**CITY OF PORTLAND, MAINE**  
**HISTORIC PRESERVATION BOARD**

September 6, 2016

Re: 135 Park Street  
CBL: 039 A014

This office has approved your application to replace twenty-six windows on the front (24) and southeast end (2) of your property at 135 – 139 Park Street. Approval is based on the plans and specifications included in the application dated June 3, 2016 (revised window specifications supplied later by Rufus Deering Company and by Kent Gordon,) and is subject to the following conditions:

Window replacements
for whole building

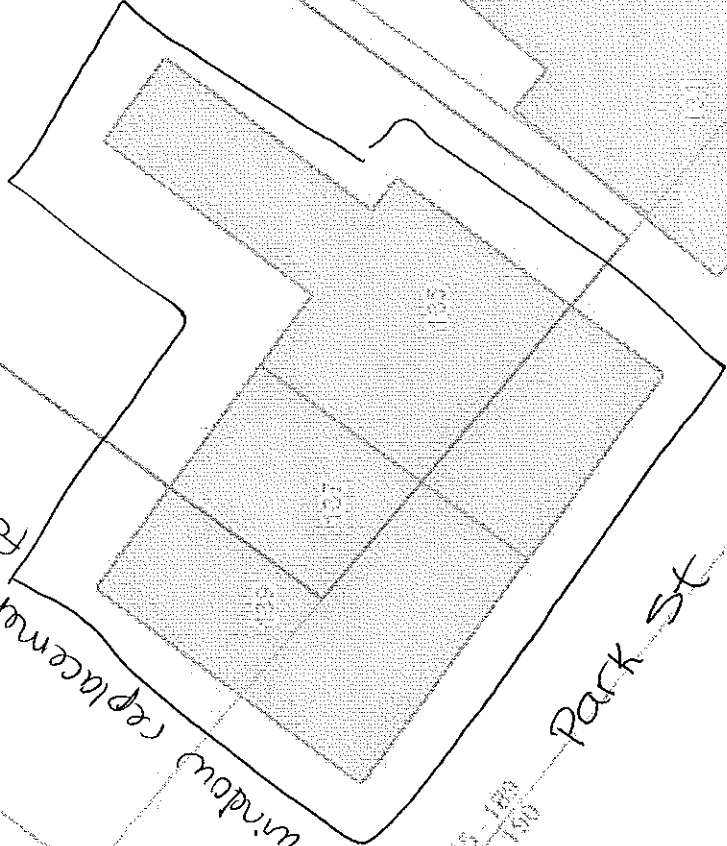
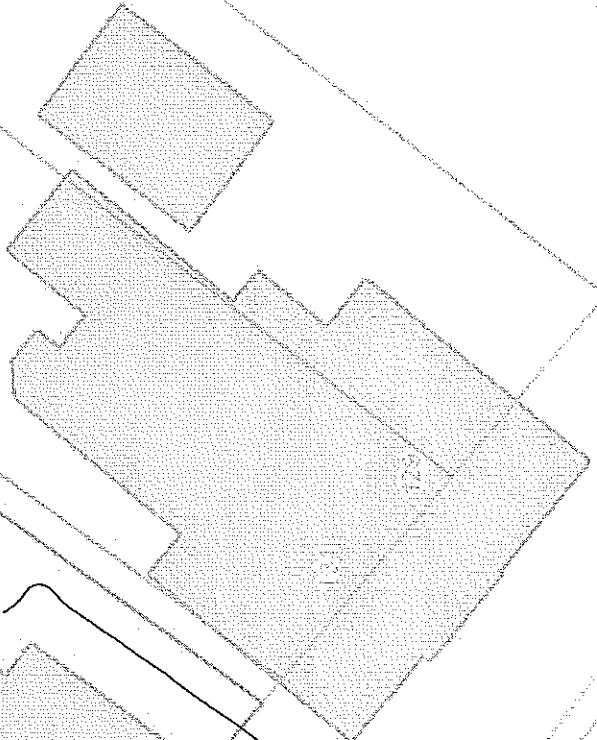
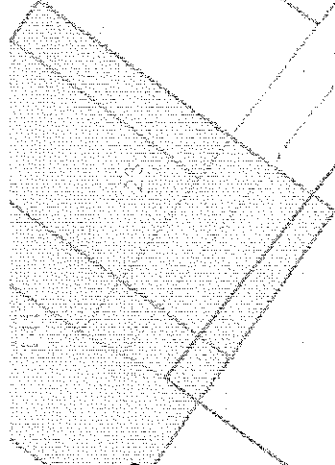
1. HP staff understands the windows are to be Jeld-Wen full-unit (not inserts) clad windows in black, with 5/8" putty glaze profile muntins - simulated divided lights (SDL) on the interior and exterior, with spacer bars. It is understood that the first and second floor windows will be 6/6 and the third floor windows are to be 3/3.
2. If screens are desired they are to be half screens.
3. Visual transmittance of the glass (VTR) is to be .7 or greater, so glass appears clear, untinted, and non-reflective.
4. Painted wood casing and brick mould is to be reproduced on site after window installation, with approximately 2" of flat casing with a staff bead moulding (Brosco B691) on top, at the edge of the masonry opening.

All improvements shall be carried out as shown in the plans and specifications submitted to staff on 6/3/16, except as specified above and as specified in the most recent specifications provided by window supplier and Mr. Gordon. Note that a building permit may be required, and this Certificate of Appropriateness is not a building permit. Changes to the approved plans and specifications and any additional work that may be undertaken must be reviewed and approved
